Subject: CU-21-00001, Siderits Storage
I-90 MP 71.77 to MP 71.89 right – Exit 71 – Tree Farm Rd.

We have reviewed the proposed site plan and have the following comments.

7-90 STORAGE
PARCEL 80-11-11-20-0-0
EASTON, KITTEN'S Co., WA
SCALE 1" = 25' PARCEL 2816.34

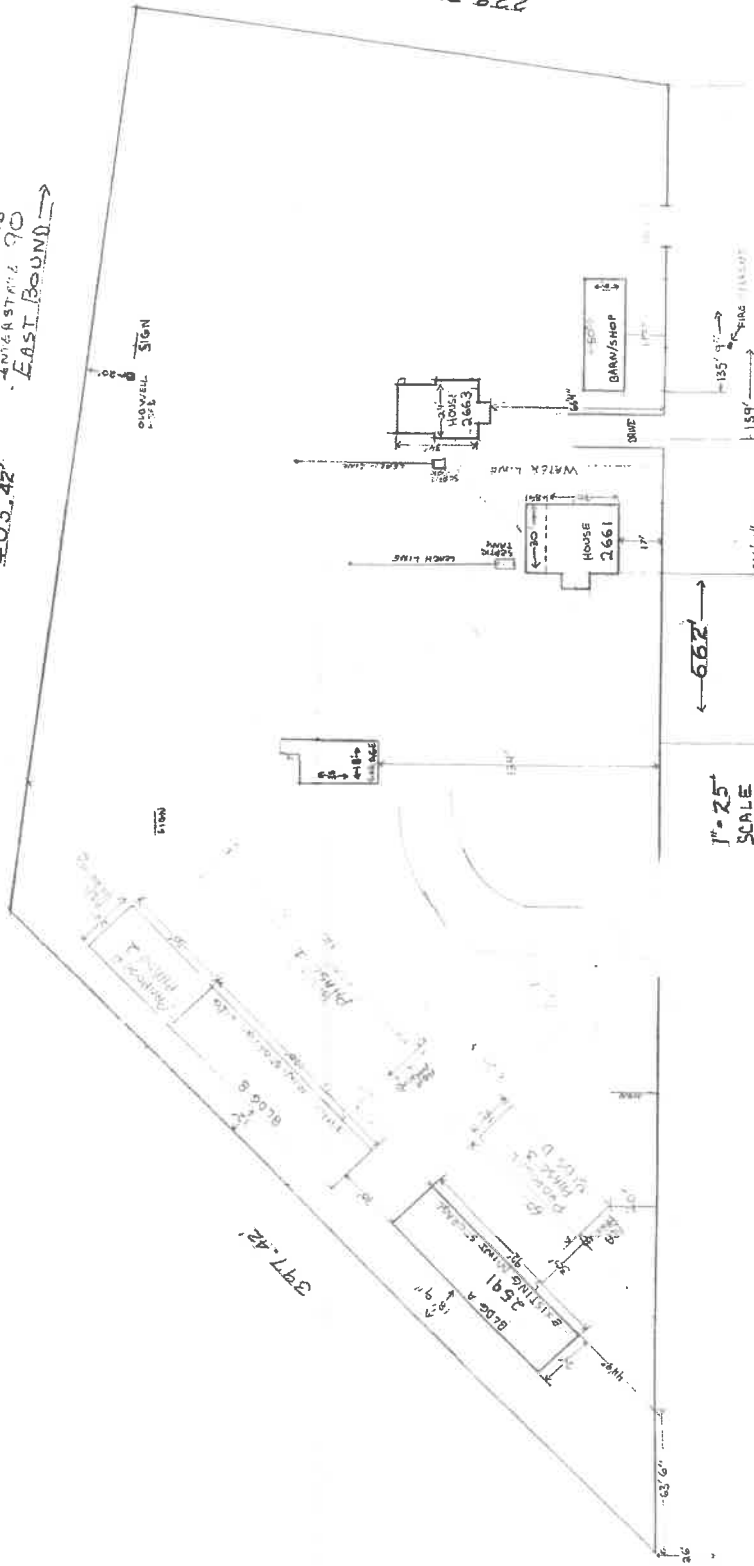
- The subject property is adjacent to Interstate 90 (I-90), a fully-controlled limited access facility with a posted speed limit of 70 miles per hour. WSDOT has acquired all access rights to the highway, including the on- and off-ramps of Exit 71. Direct access to I-90 or within the limited access boundary is strictly prohibited.

- Stormwater and surface runoff generated by this project must be retained and treated on site. Any discharge of stormwater into I-90 right-of-way will require an approved utility permit.

- Any snow accumulated on the property shall not be moved onto WSDOT right-of-way. We encourage the proponent to not underestimate the potential for large volumes of snow and designate a snow storage area on the property.

- Any proposed lighting must be directed down towards the site and away from I-90.
- Any outdoor advertising or motorist signing considered for this project will need to comply with state criteria. Please contact Trevor McCain of the WSDOT Headquarters Traffic Office for specifics. He can be reached at (360) 705-7282.

- The existing six-foot tall right-of-way fence typically lies one-foot inside our right-of-way boundary and must not be altered or moved.
